**Orsted Onshore Ireland Midco Limited**

## **3: MEMORANDUM RESPONSE TO SUBMISSIONS RECEIVED**

### **BIODIVERSITY**

Proposed Oatfield Wind Farm Project, Co. Clare: ABP  
Case No. ABP-318782-24

Figure 1- 20: Regional Context - Managed Areas for Hen Harrier, Red Grouse and other key ecological features

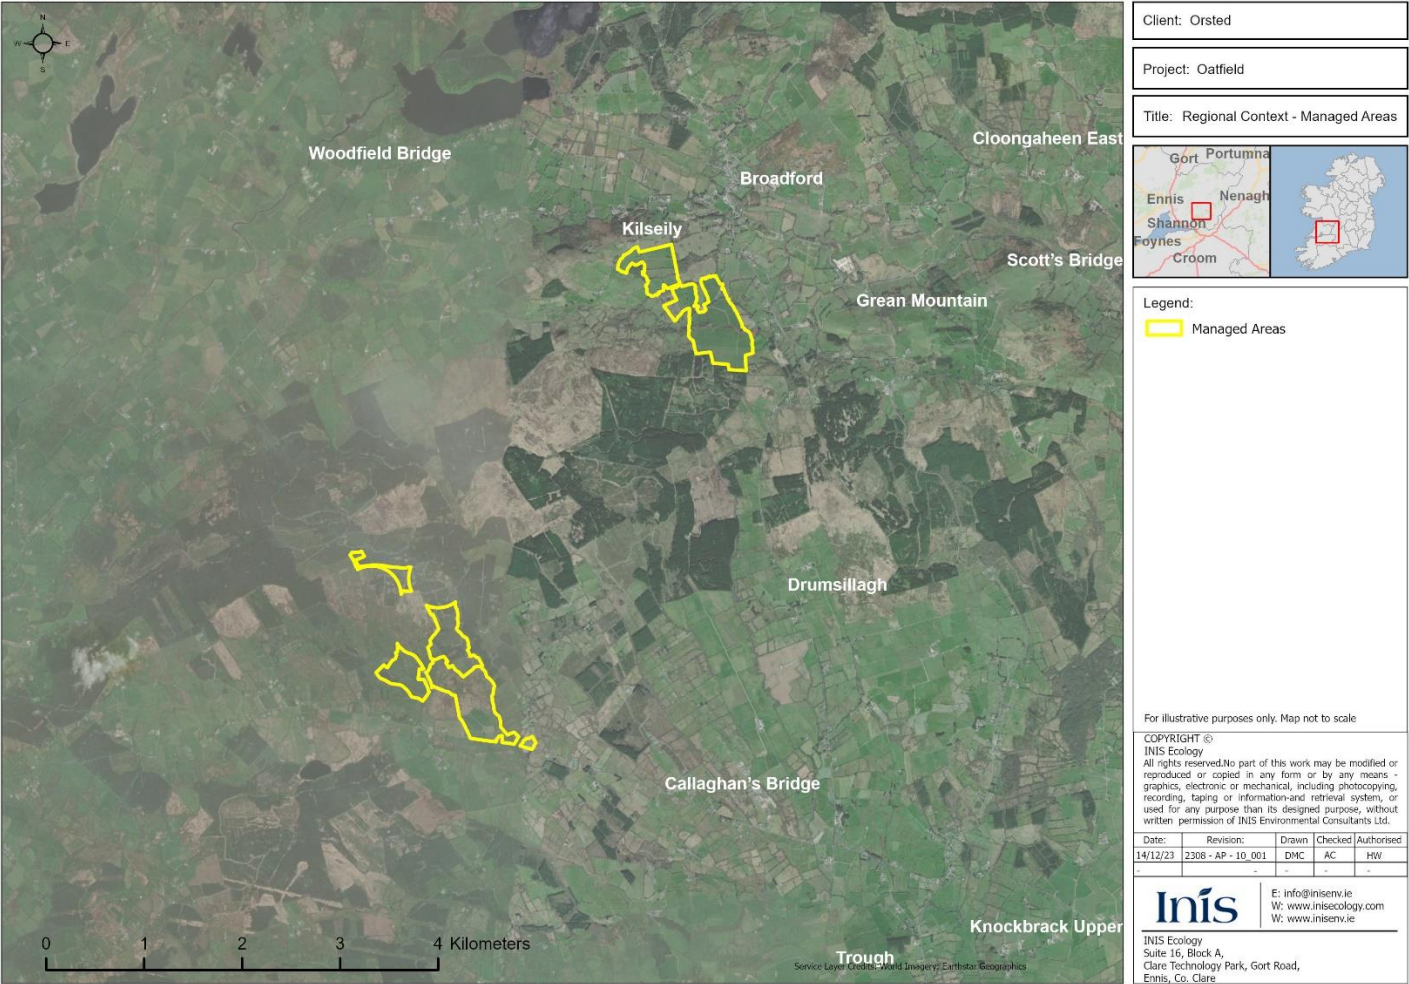
The version of the SHMP submitted in December 2023 (see **Appendix 7.1** of the **EIAR Chapter 7 Biodiversity**, hereafter referred to as **EIAR Chapter 7**) indicated an area of land not within the landowner agreement schedule (i.e. Figure 1.20, Figure 1.21, Figure 1.22 and Figure 1.24). This was purely a presentation matter and calculations regarding adequacy of compensatory habitats etc. were correct in the original submitted document. The figures referred to above have since been amended in an updated SHMP which can be found in Appendix 1 below.
